**App no: 22.0982**

**Address: Former Public Toilets Market Place Longridge**

**Proposal: Proposed demolition of existing derelict toilet block and erection of a new single storey dwelling.**

The submitted documents and plan 'Proposed site plan' JM-0254-003-Rev A have been reviewed and the following comments are made.

**JM-0254**  
**PROPOSED**  
**SITE PLAN**

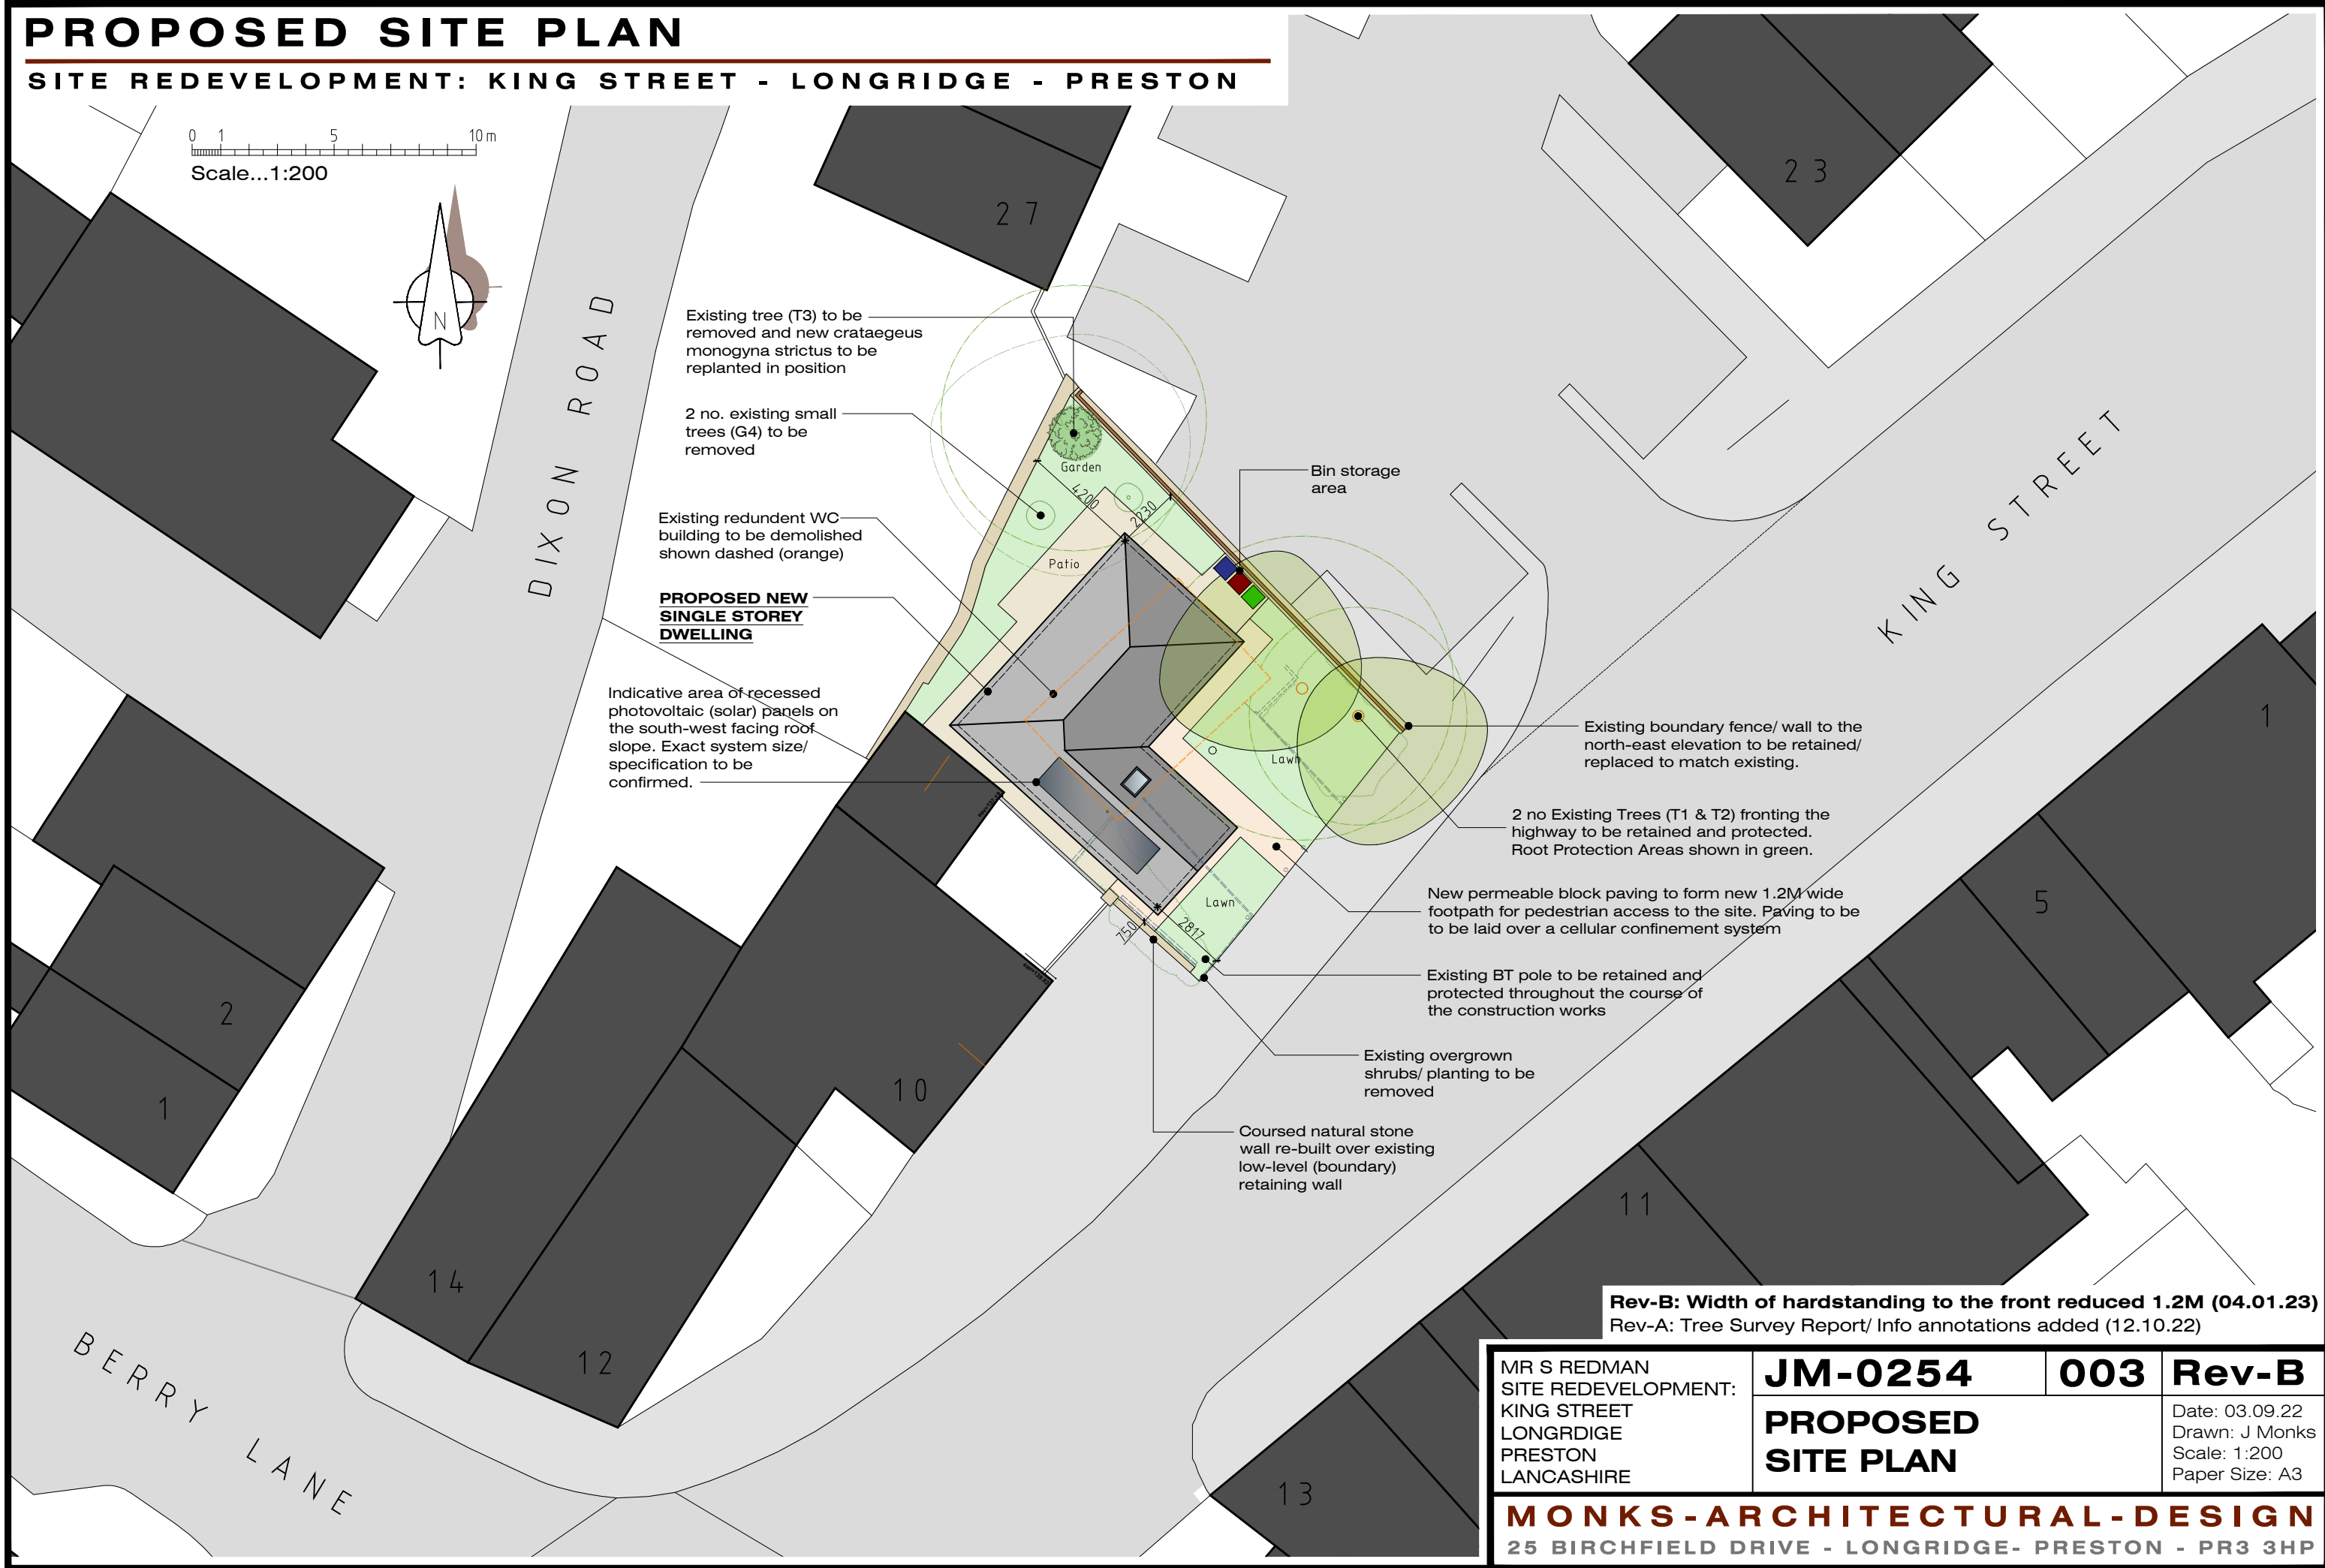
The site plan proposes a block paved car parking space measuring 6.4m long by 2.6m wide. The size prevents the vehicle from being able to turn and exit onto Market Place in forward gear. The paving is bound and porous and is considered acceptable.

This will require a new vehicle crossing on Market Place B5269 which is subject to a 30mph speed limit. There is a surface water road gully along the frontage of the site.

The vehicle crossing causes conflict with the adjacent road junction and bus stop, where the kerb tapers across the development site. The single parking space will require a reversing manoeuvre on the adopted highway which is a classified road carrying a significant volume of traffic of approximately 8000 vehicles a day, with a high percentage of heavy vehicles of approximately 8%.

The Highway Authority would object to the new vehicle crossing required for the car parking space at this location due to conflict with highway users on a busy section of classified road.

Should the application be considered for approval we would require the off-street parking bay, accessed from Market Place, removed from the scheme and a secure, cycle store being provided.

The site is located within walking distance of mainline bus services and local facilities and could support residents without a car. However, we would seek to secure a car parking place and electric vehicle charging point at the dwelling with a potential alternative point of access on King Street, which is adopted highway.
